**EL PASO COUNTY PLANNING AND
 COMMUNITY DEVELOPMENT
 DEPARTMENT**

GRADING AND EROSION CONTROL PLAN CHECKLIST

GRADING & EROSION CONTROL PLAN
CLAREMONT BUSINESS PARK 2 FIL. NO. 1 - LOT 1
JOB NO. 44-037
DATE PREPARED: SEPT 04, 2020
DATE REVISED: DECEMBER 1, 2020

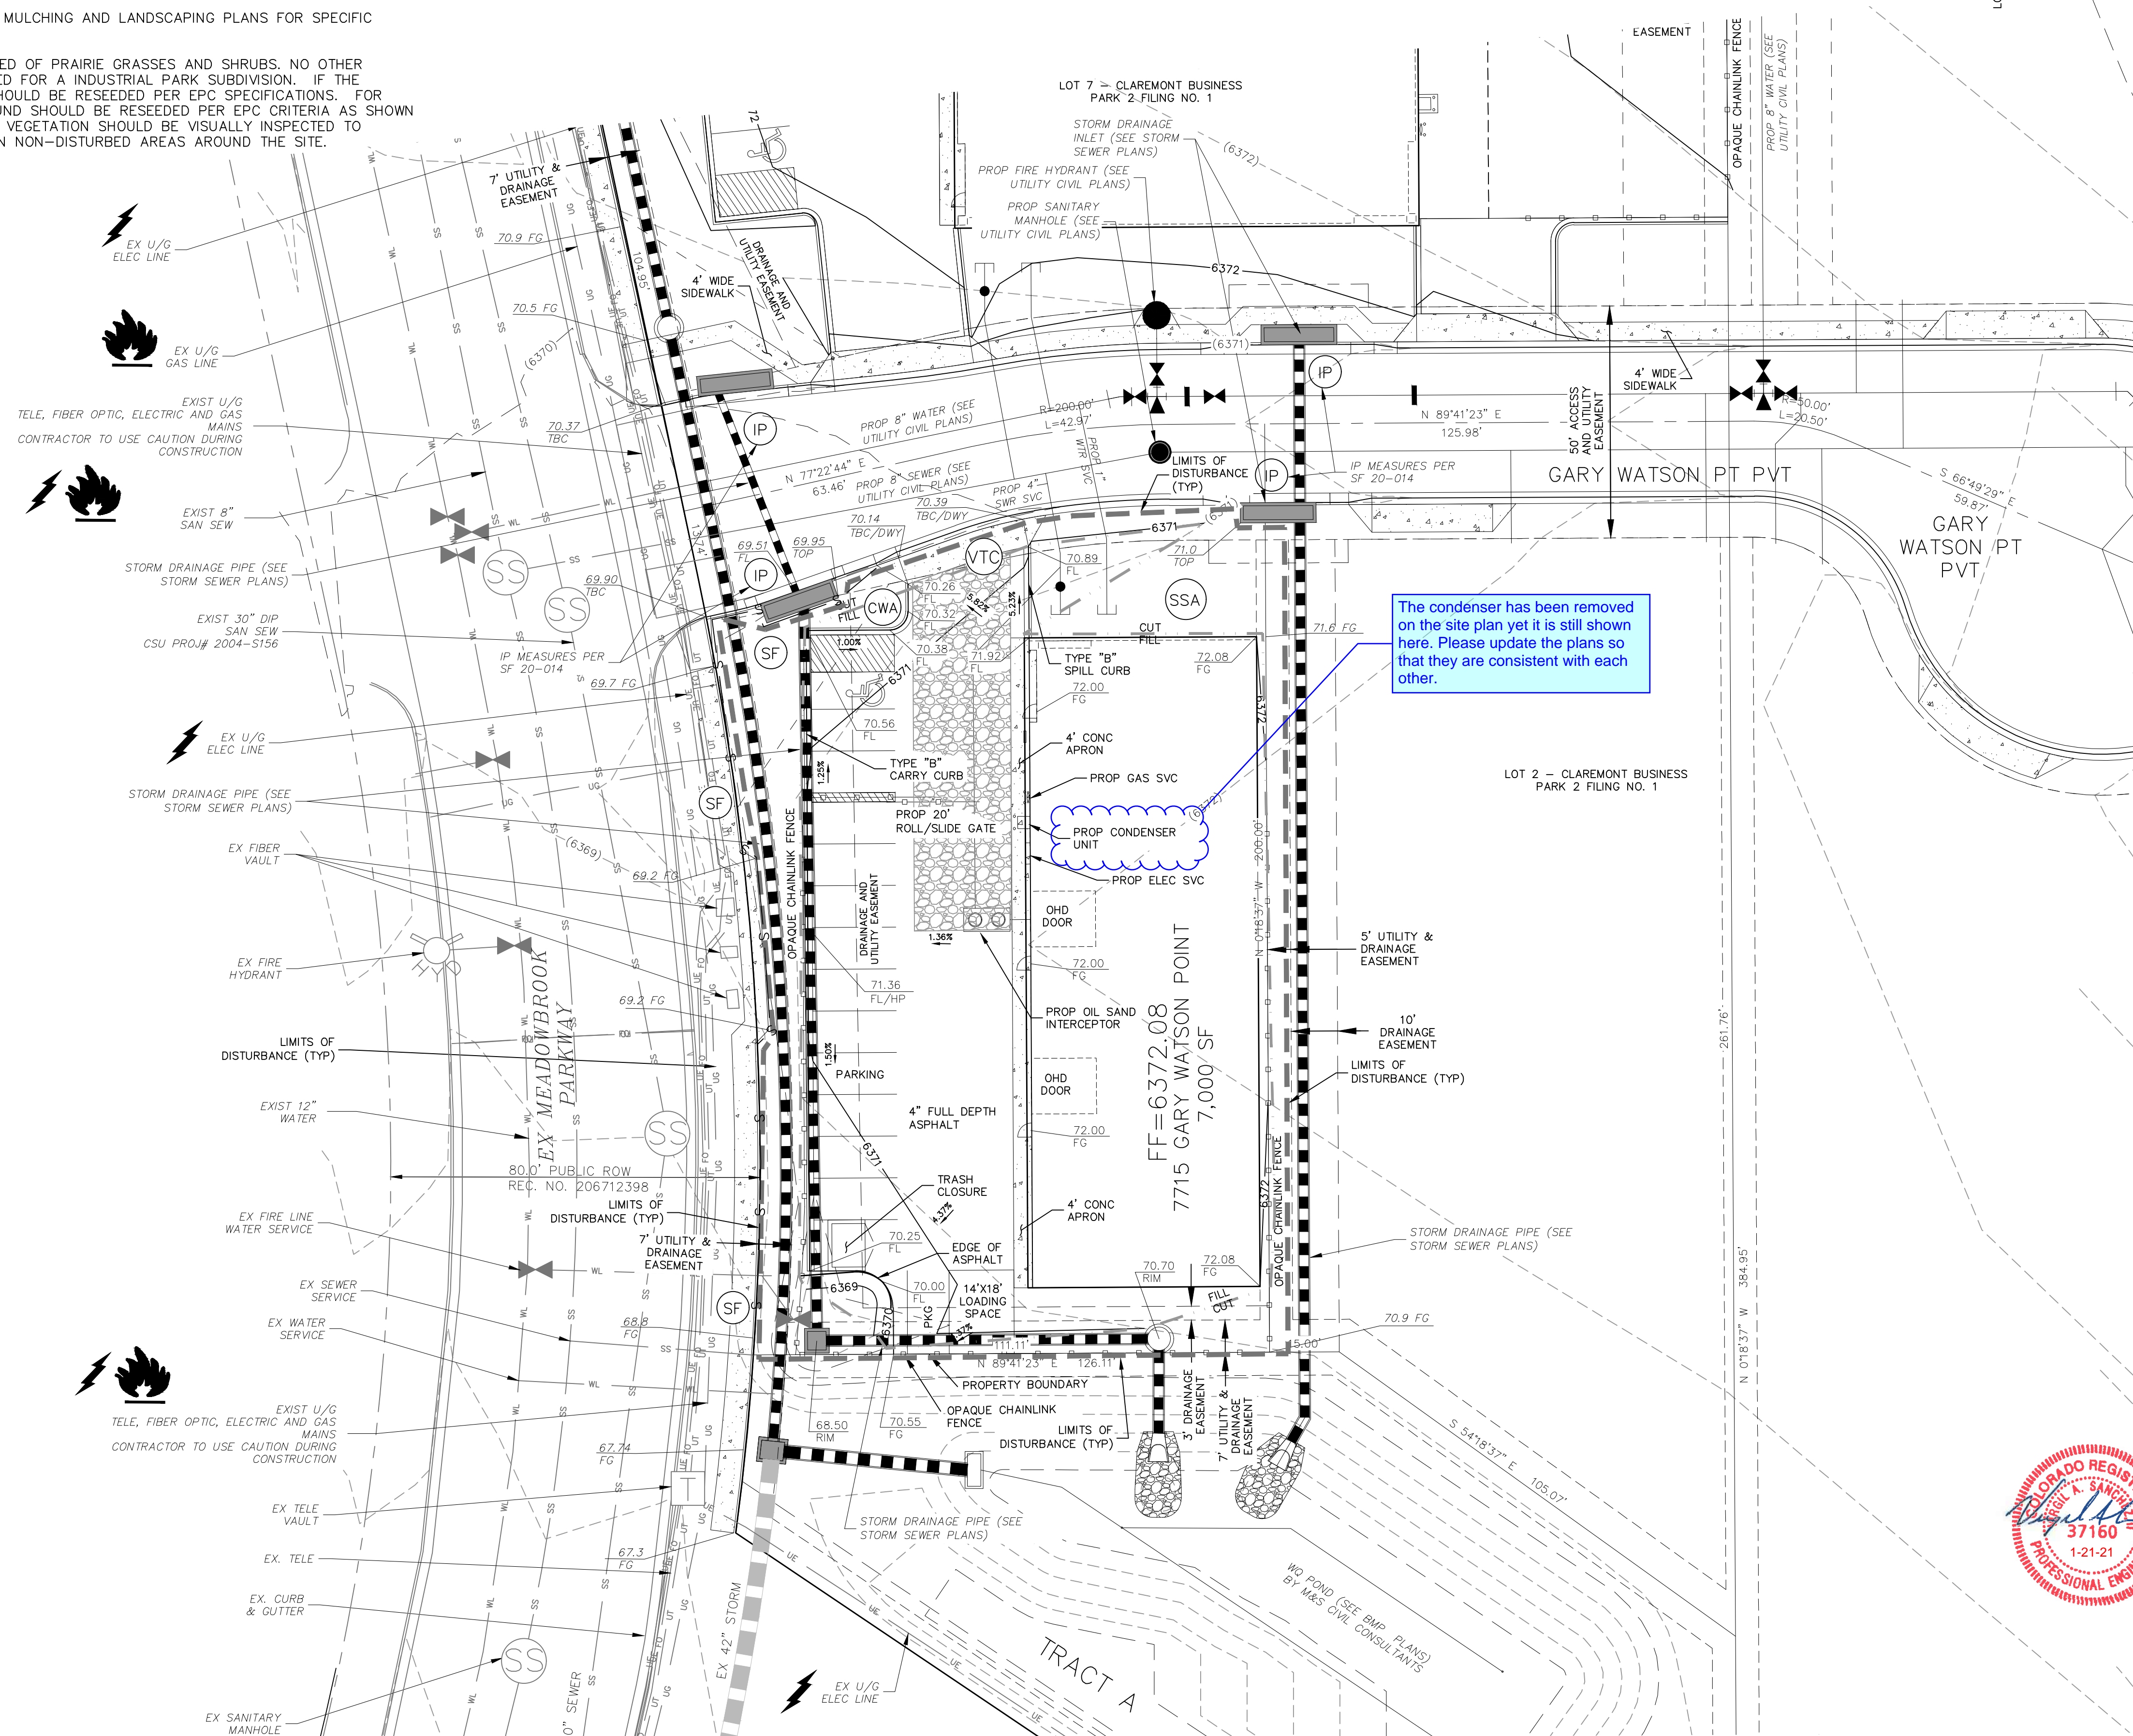
Applicant	PCD
1. GRADING AND EROSION CONTROL PLAN			
a	Vicinity map.	X	✓
b	Adjacent city/town/jurisdictional boundaries, subdivision names, and property parcel numbers labeled.	X	✓
c	North arrow and acceptable scale (1"=20' to 1"=100').	X	✓
d	Legend for all symbols used in the plan. Add drainage flow arrows to Legend	X	X
e	Existing and proposed property lines. Proposed subdivision boundary for subdivision projects.	X	✓
f	All existing structures.	X	✓
g	All existing utilities.	X	✓
h	Construction site boundaries.	X	X
i	Existing vegetation (notes are acceptable in cases where there is no notable vegetation, only grasses/weeds, or site has already been stripped).	X	X
j	FEMA 100-yr floodplain.	N/A	N/A
k	Existing and proposed water courses including springs, streams, wetlands, detention ponds, stormwater quality structures, roadside ditches, irrigation ditches and other water surfaces. Show maintenance of pre-existing vegetation within 50 feet of a receiving water.	N/A	N/A

VTC-1. AGGREGATE VEHICLE TRACKING CONTROL

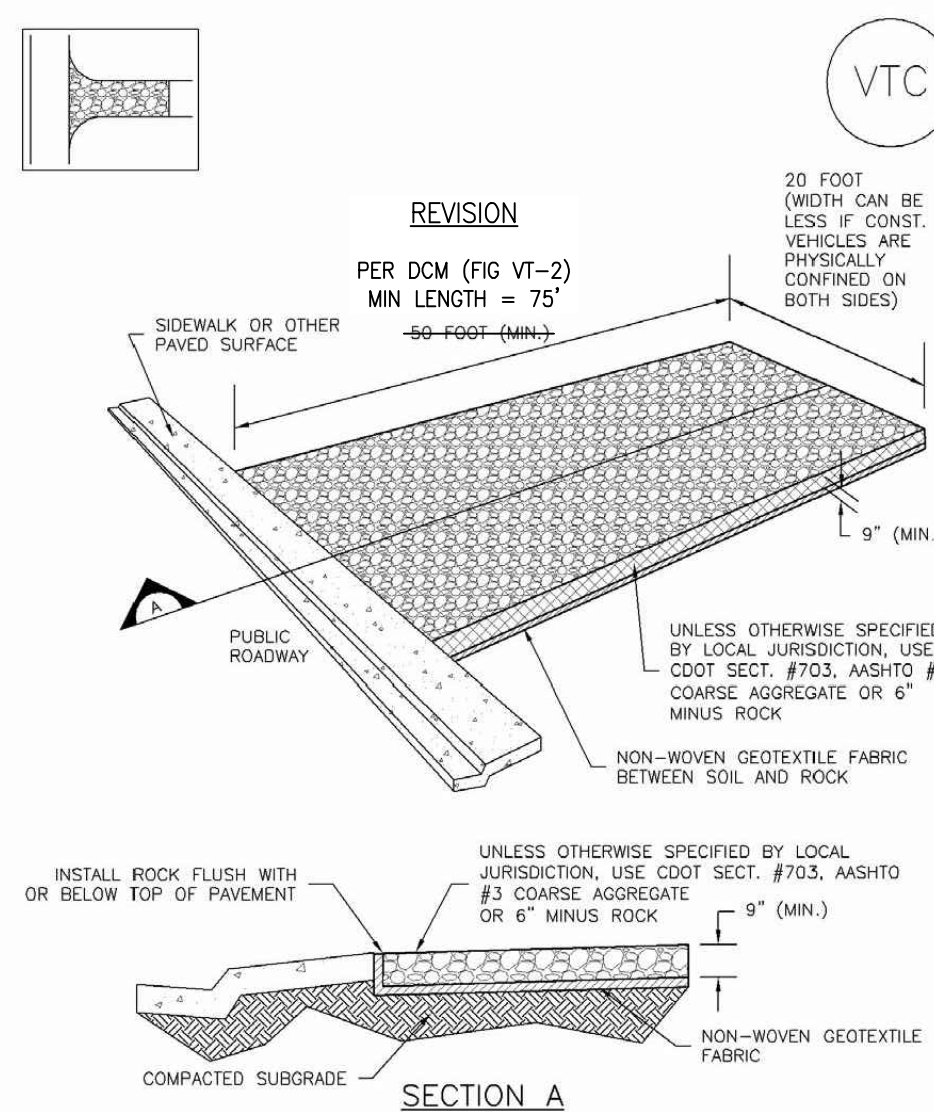
v	All proposed temporary construction control measures, structural and non-structural. Temporary construction control measures shall be identified by phase of implementation to include "initial," "interim," and "final" or shown on separate phased maps identifying each phase.	X	✓
w	Vehicle tracking provided at all construction entrances/exits. Construction fencing, barricades, and/or signage provided at access points not to be used for construction.	X	✓
x	Temporary sediment ponds provided for disturbed drainage areas greater than 1 acre.	N/A	N/A
y	Dewatering operations to include locations of diversion, pump and discharge(s) as anticipated at time of design.	N/A	N/A
z	All proposed temporary construction control measure details. Custom or other jurisdiction's details used must meet or exceed EPC standards.	X	X
